12 August 2025

Re: Planning application 2025/62/91854/E

Change of use of land and formation of a tennis court with associated external alterations at 1 Barnsley Road, Flockton, Huddersfield, WF4 4DN

Drawing
Proposed Block Plan & Detail of Fencing
around Tennis Court

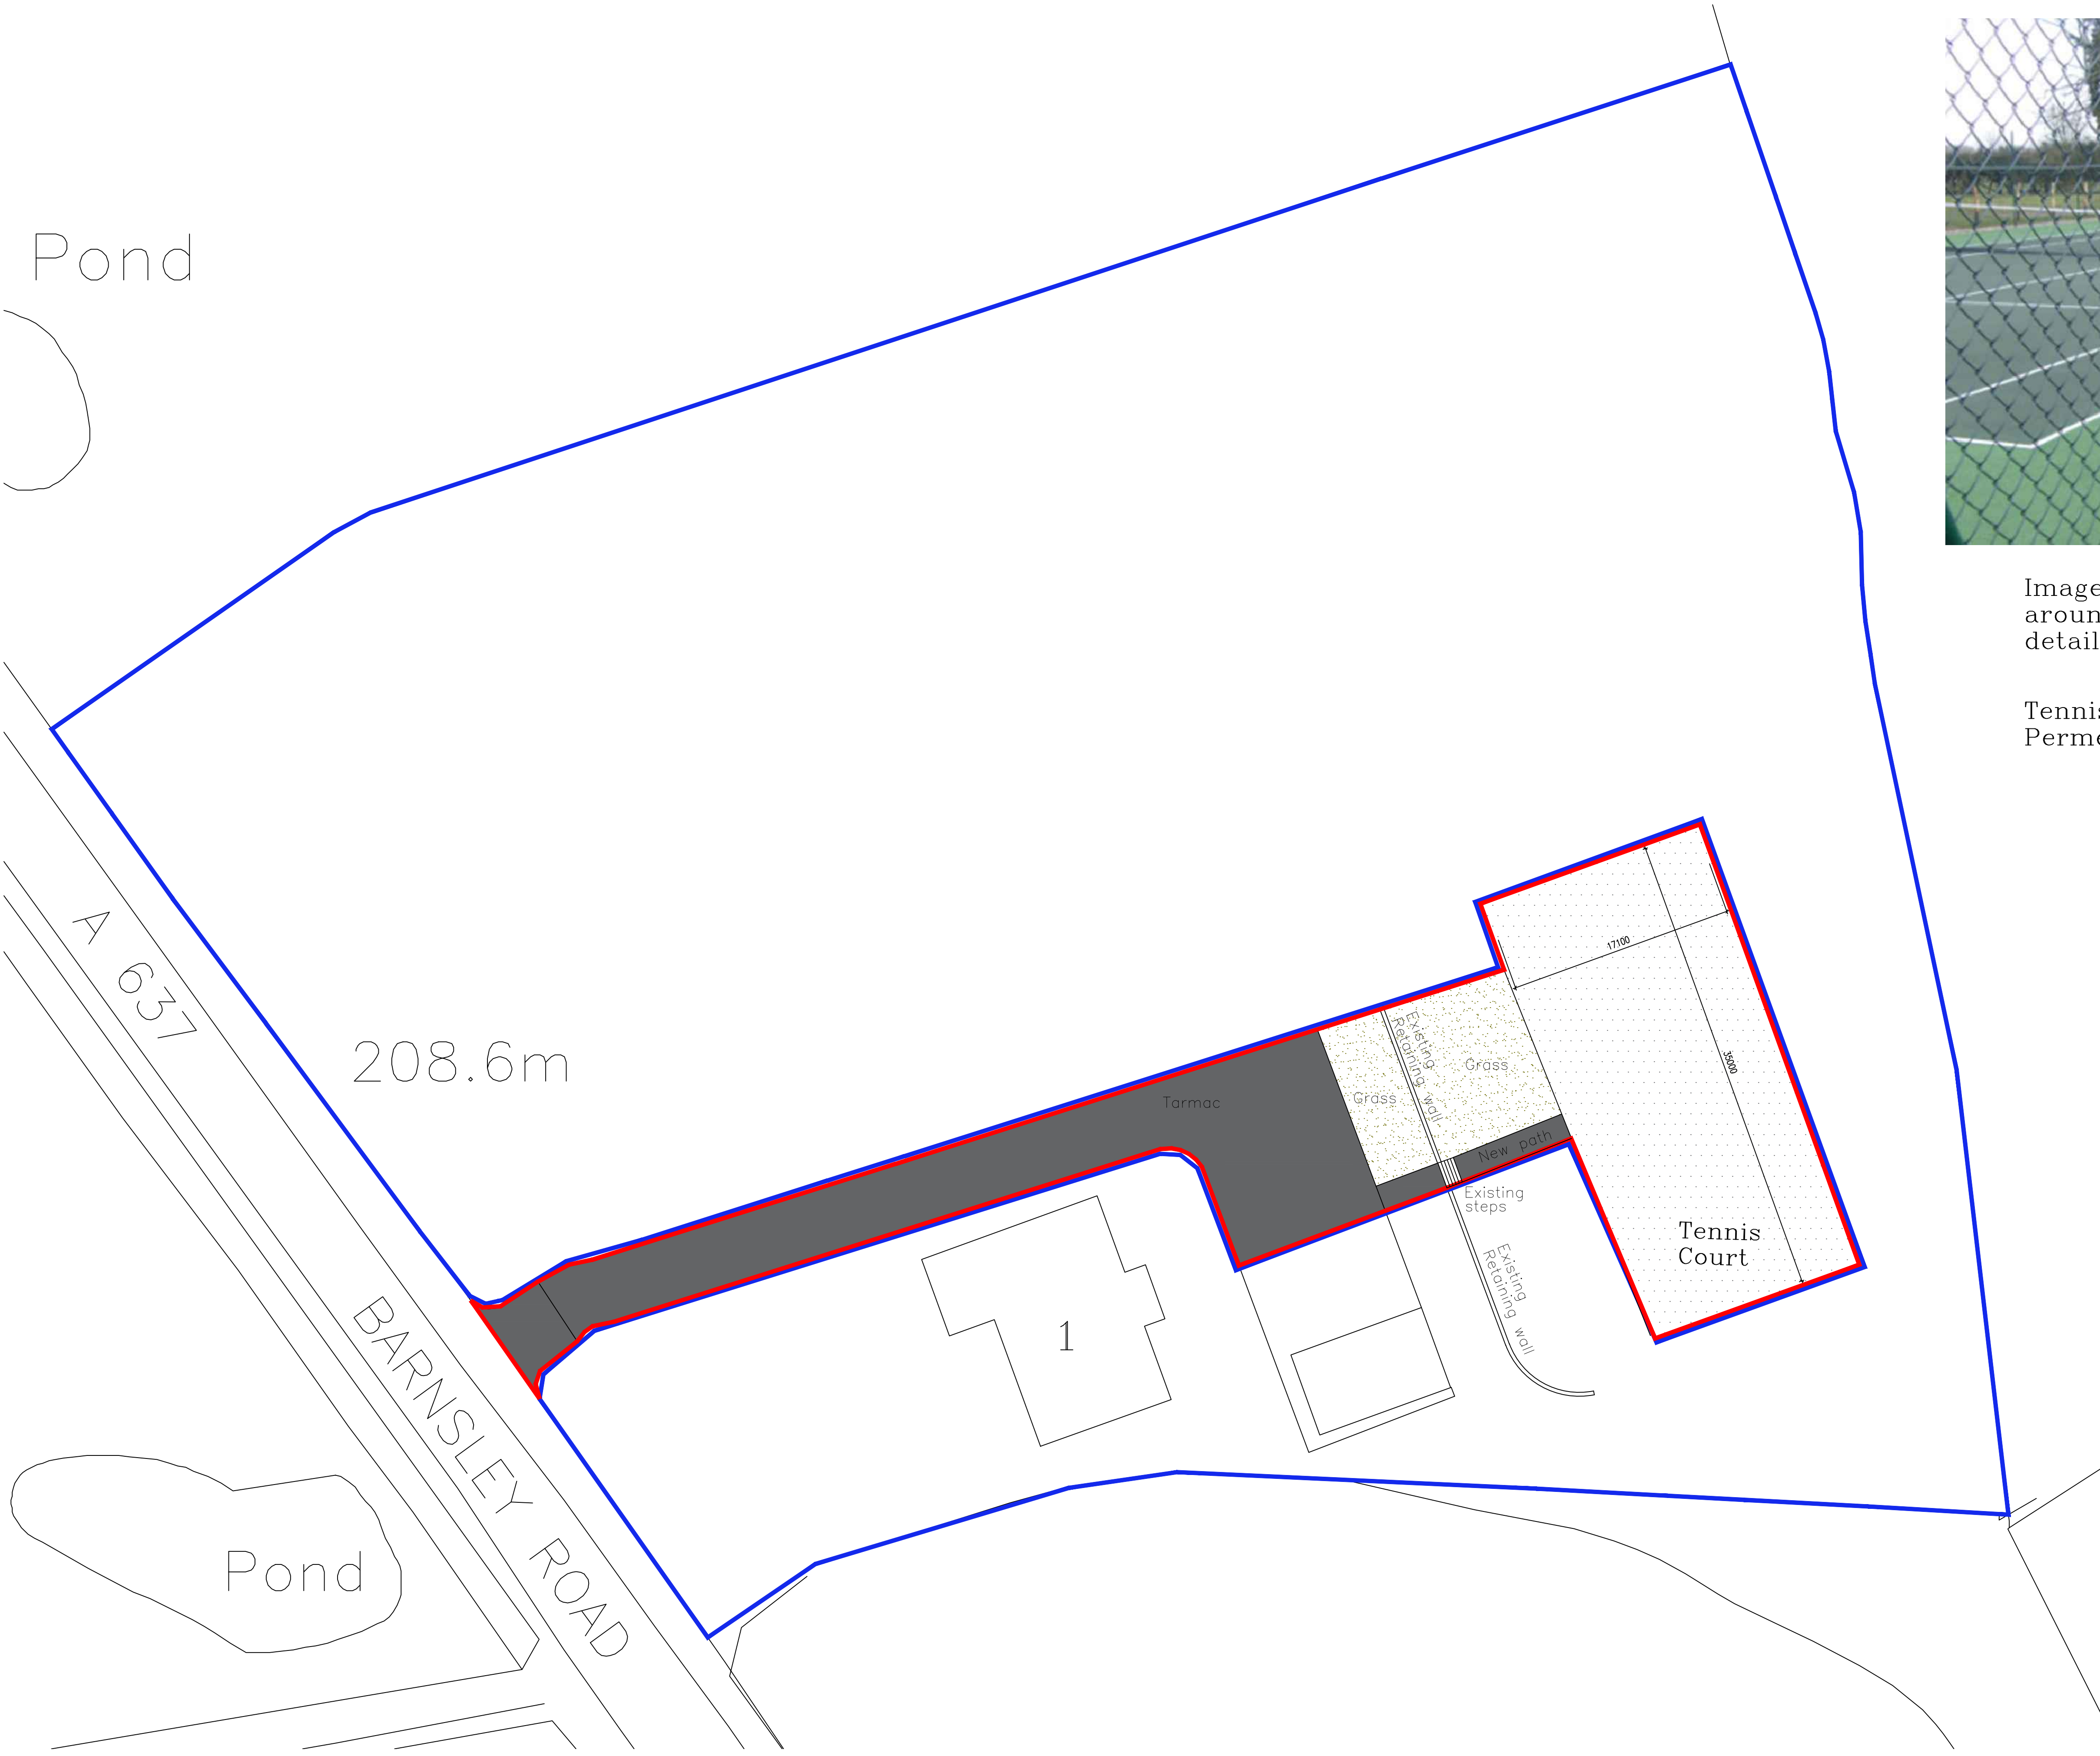
In the light of the above, we note that the new planning application seeks permission for the change of use of land and the formation of a tennis court, including associated external alterations. The Cover Letter submitted with the application, dated 7th July 2025, highlights that *'as illustrated by the site planning history for both the erection of the dwelling, removal of the spoil heap and regrading of the land, and subsequent discharge of conditions, all coal mining and contamination remediation works have taken place.'* It further notes that *'the nature of the works, for the installation of a tennis court is not considered to require significant ground works that would be below any depth of any previous land levelling.'* This shows that the proposed development would not require significant groundworks or earthworks to facilitate the development due to the previous approved planning application. As such, the development is considered to fall under part B on the Coal Authority's exemptions list, exempt by nature of development. However, the mine entries do pose a potential public safety risk to those utilising this area, which is of significant concern.

The LPA needs to be satisfied that the site is suitable and safe for the new use and may consider it prudent to require additional information from the applicant in this regard. The applicant should demonstrate to you that they are aware of the recorded mine entries and their zones of influence, they have assessed their relationship to the development and are satisfied that they pose no risk.
